From: Laura Gibbons
Sent: 13 June 2019 09:32
To: Planning.Responses
Cc: Anita Gardner
Subject: RE: Planning Consultation on EP/64/19/DOC

Engineers Comments Regarding Condition 8- surface water drainage design

Site Address: Scorton 9 Lime Tree Close East Preston BN16 1JA

Description of Works: Approval of details reserved by condition imposed under EP/52/18/PL relating to conditions 8-surface water drainage & 9-maintenance & management of surface water drainage system.

Drawing No: X:\PROJECTS\4501_Marmont_EastPreston\Plans\4501_Marmont_EastPreston_DrainageLayout.dwg

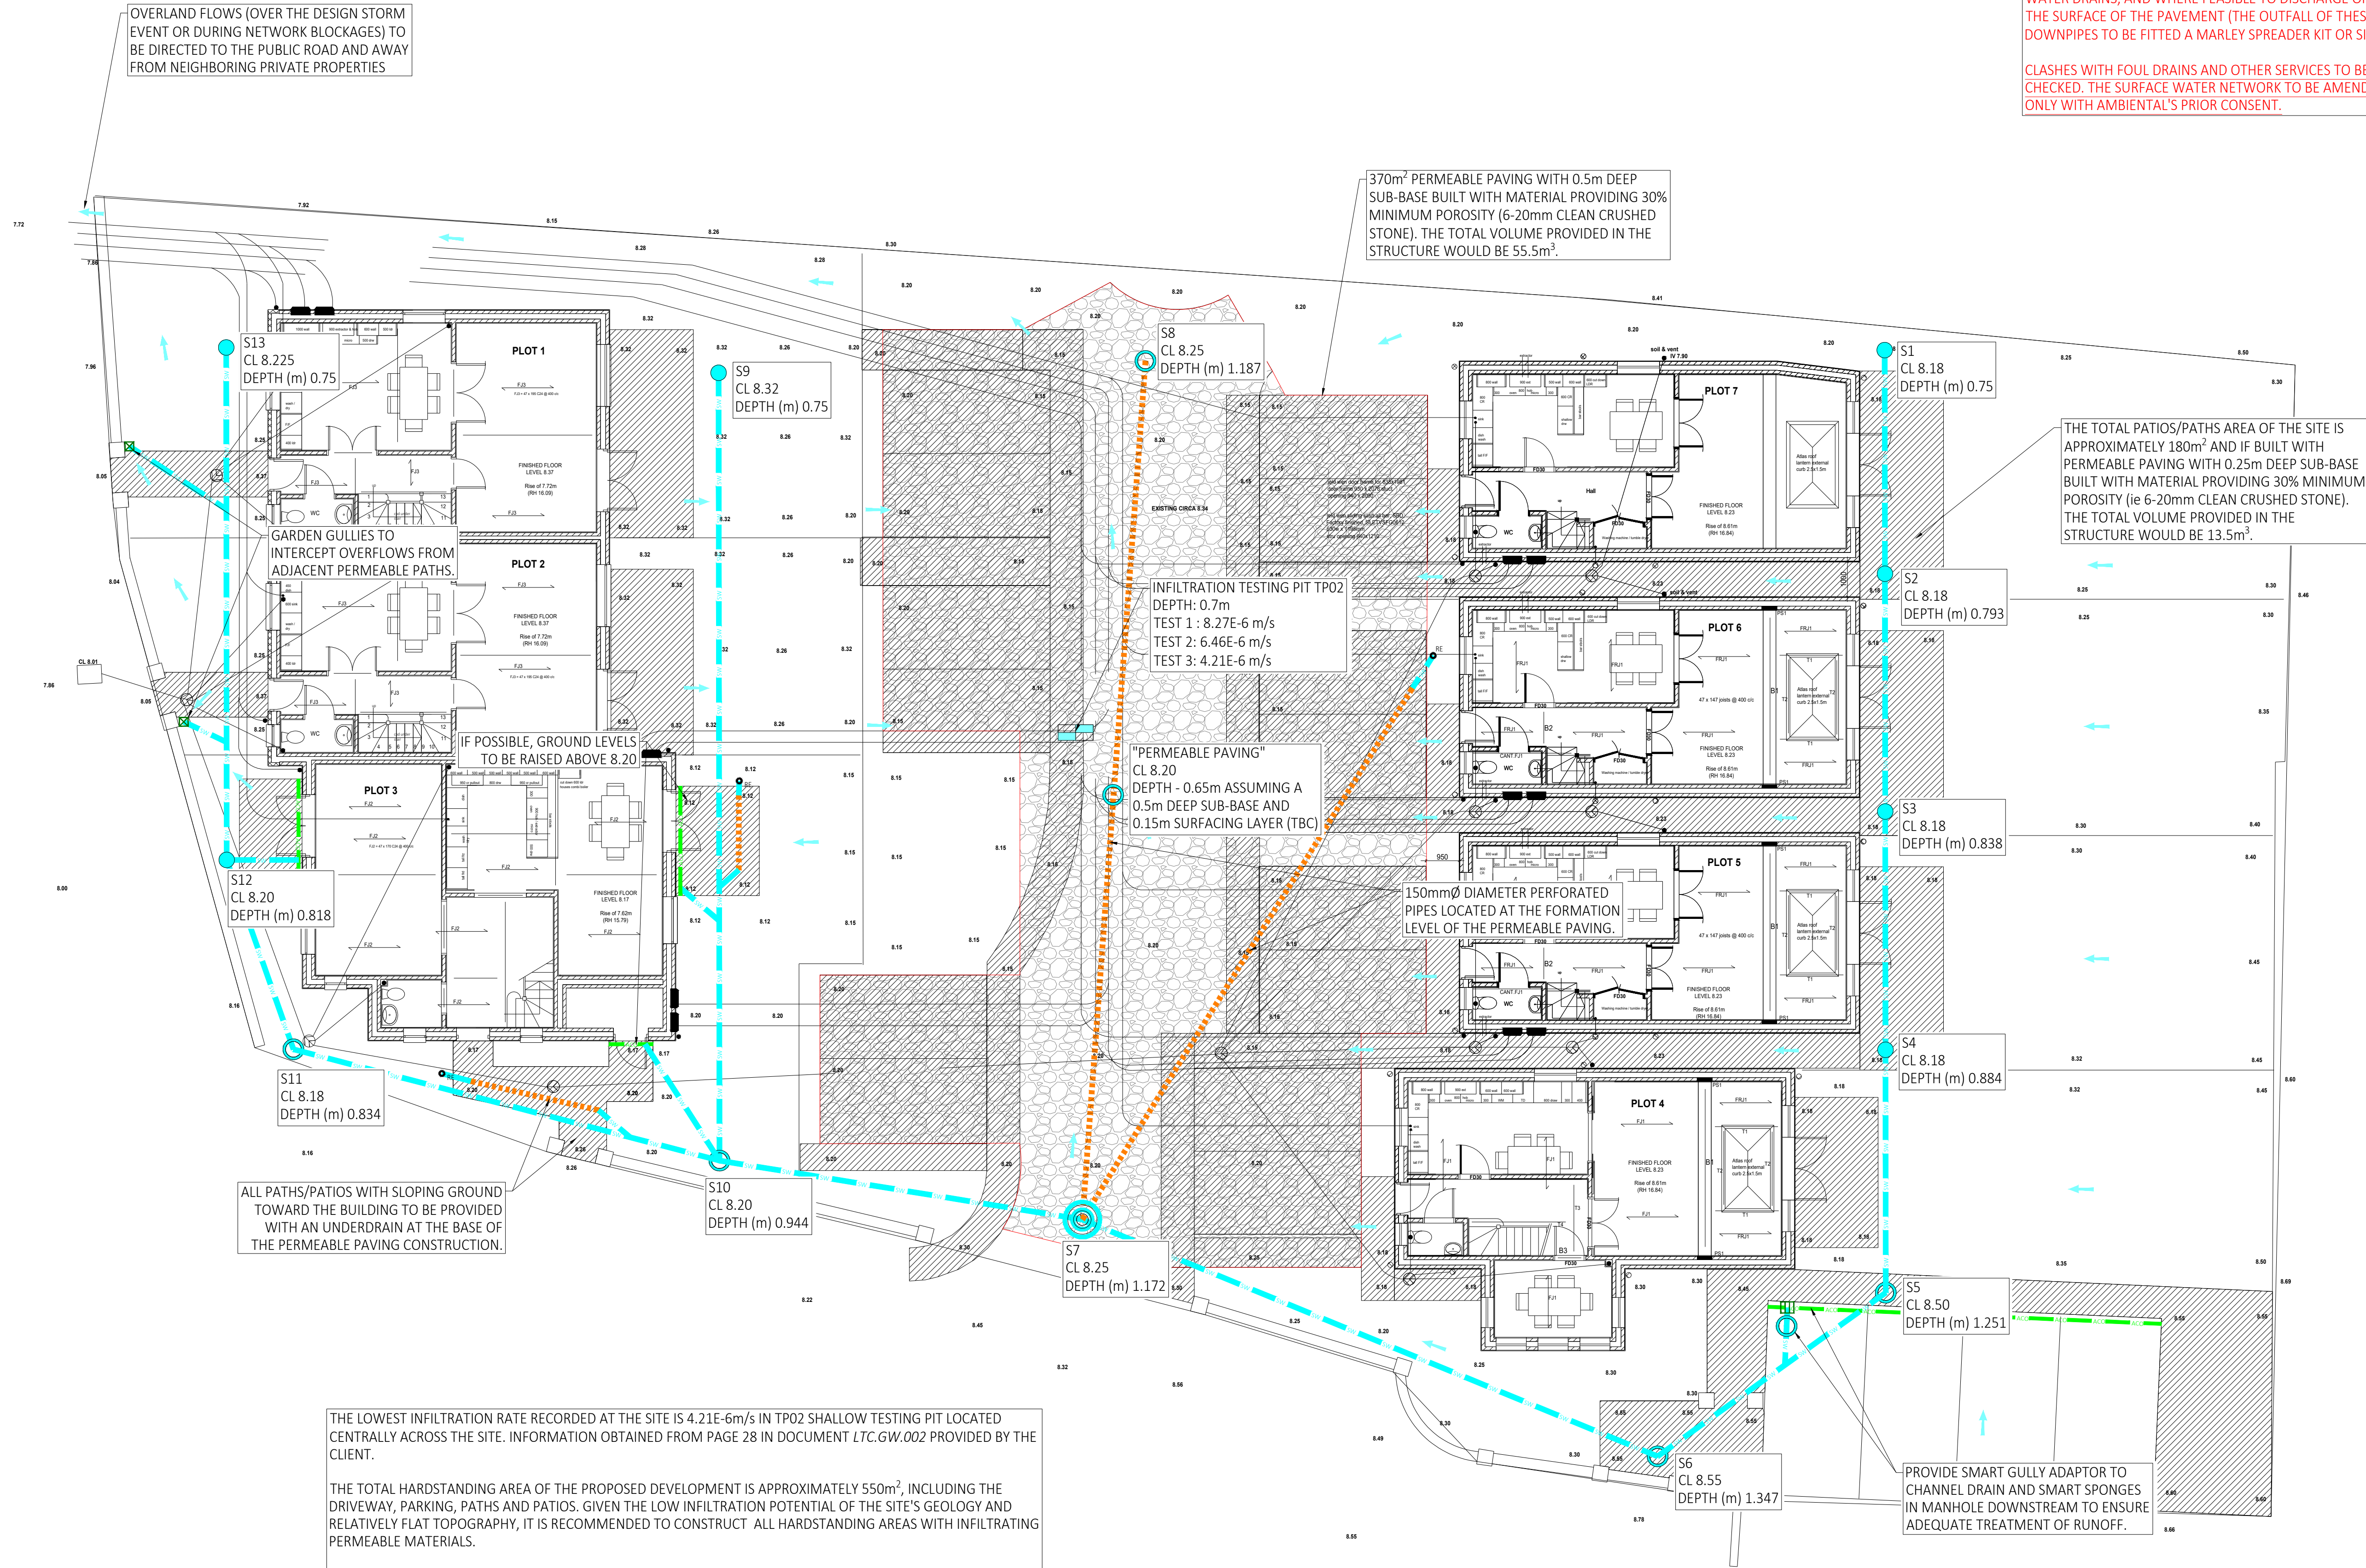
The drainage layout drawing conflicts with the surface water drainage document. Please can it be confirmed which of these is the proposed solution.
